From:
Sent: 12 October 2025 19:21
To: Planning Portal
Subject: FAO Morgan Braithwaite Re: Planning Portal Reference: 2025/92698
Attachments:

2025/92698

11, Heathdale Avenue, Birkby, Huddersfield, HD2 2XT

Erection of single storey rear extension and alteration of flat roof to duo pitched roof over garage

Proposed 3D Views

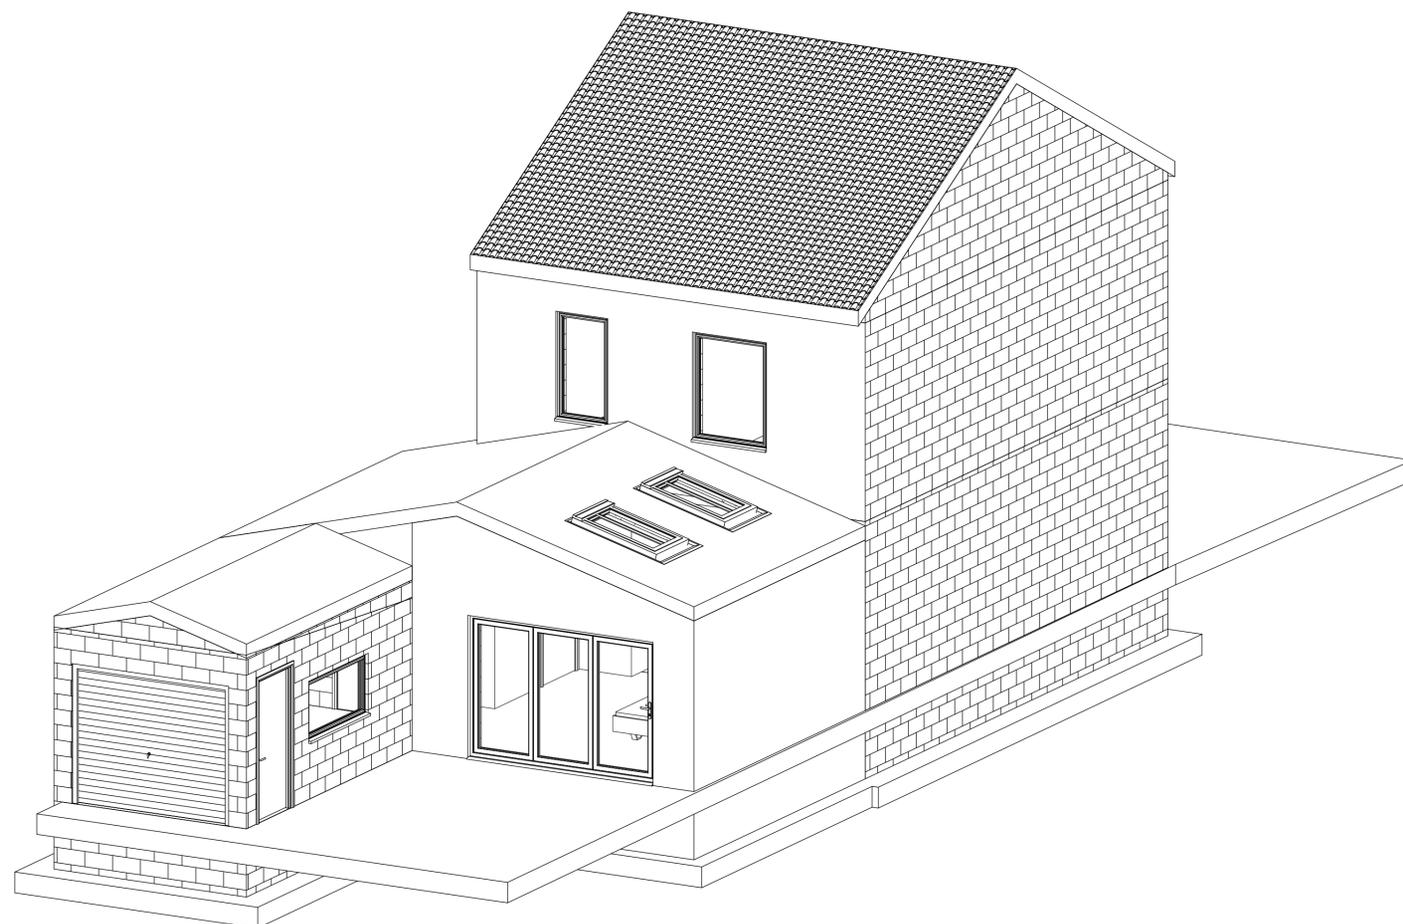
Another concern is the positioning of the skylights which will no doubt impinge on the privacy of anyone resident at No. Based on the illustrations submitted these are potentially in direct line of the main bedroom on this side of the house.

Drawing Title:
Proposed Elevations

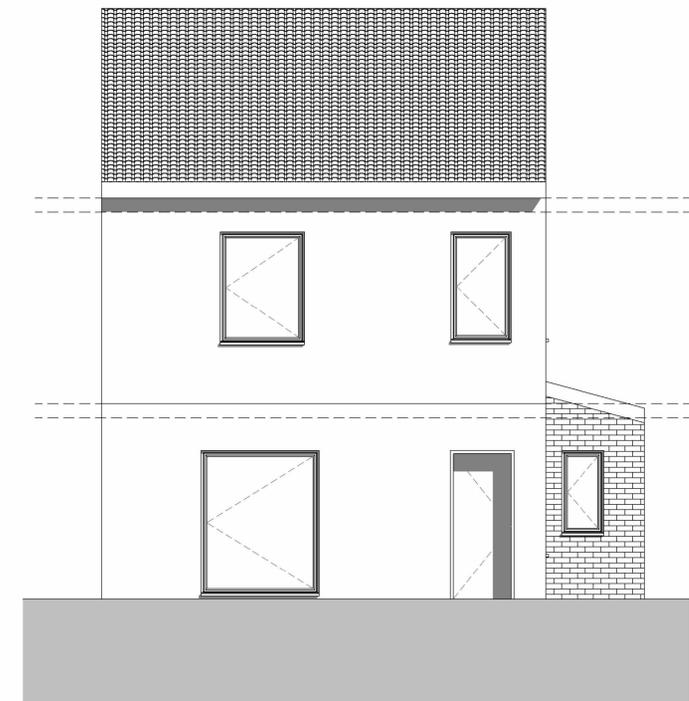
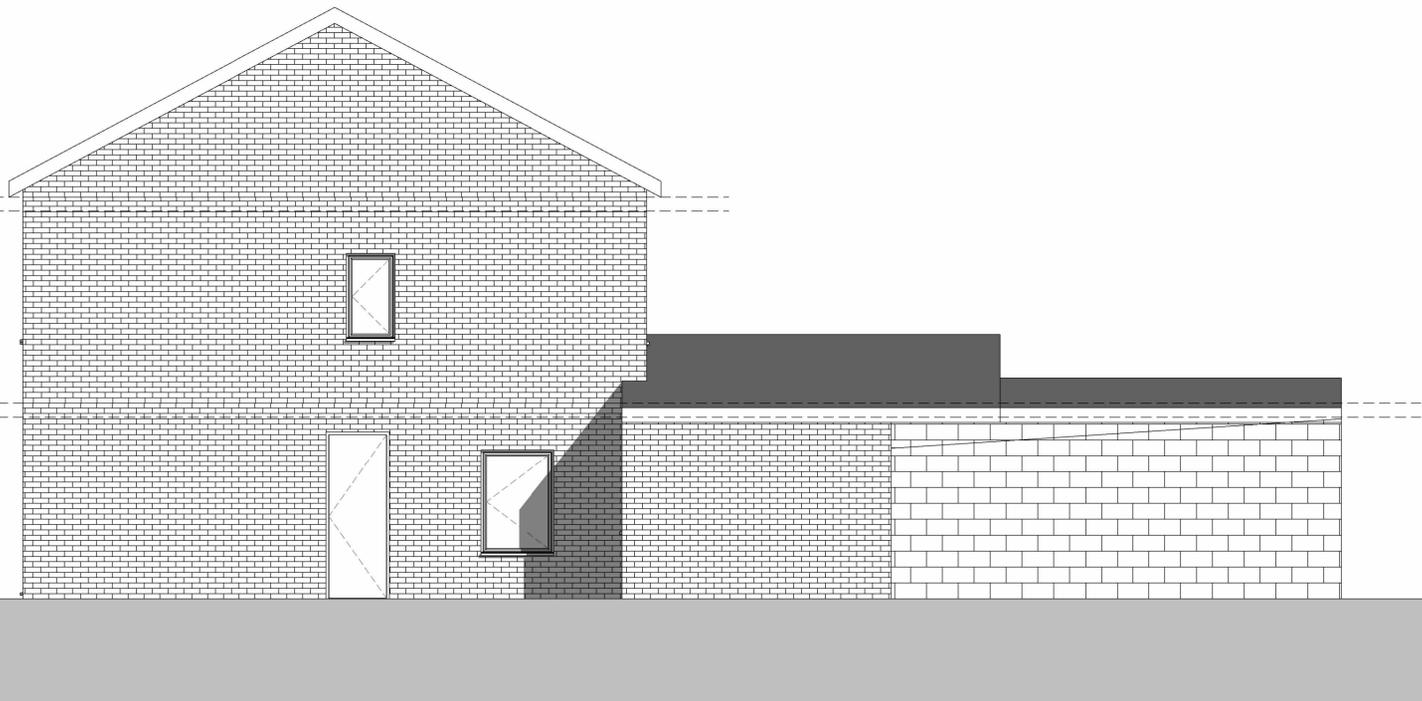
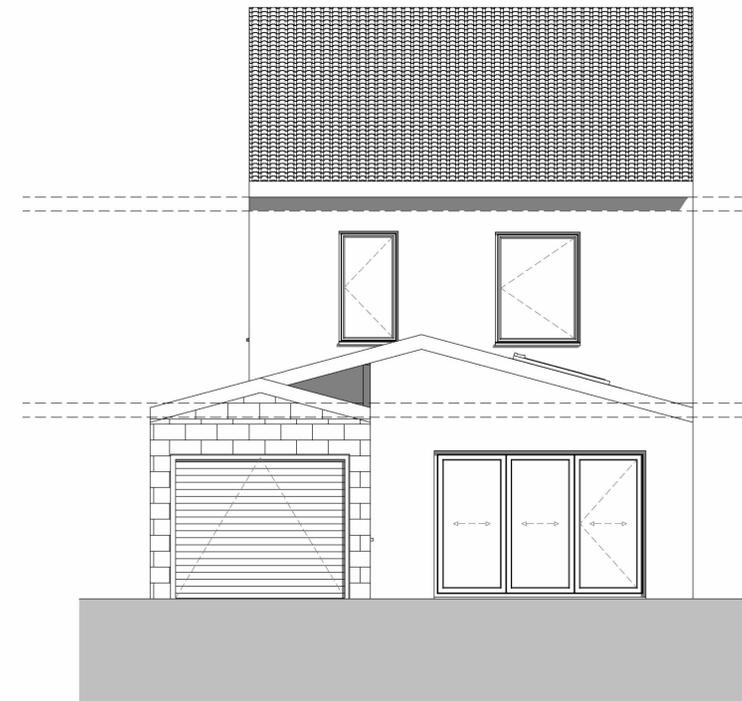
Where the trees are currently located, this is where I am assuming the outer wall will be built if it to be in line with the rest of the property as illustrated in the submitted drawings. It would be helpful to know how this outer wall will be built without removing these trees, which given their size does not appear to be feasible that the extension could be built without their removal.

This is very concerning as I am aware standing that far out privacy will be affected through double skylight windows where it is easier to covertly look up at an angle straight into the window of the bedroom seriously compromising privacy. Please refer to pictures attached.

Finally, I could not find details of the height of the proposed extension as I also have concerns of it blocking sunlight into the back living room and kitchen due to overshadowing of the build itself if it is too high. Reduced sunlight is likely to have an impact on the quality of living, as they rely on the garden and natural sunlight it affords as part of their health and wellbeing. this is often their only outside space.
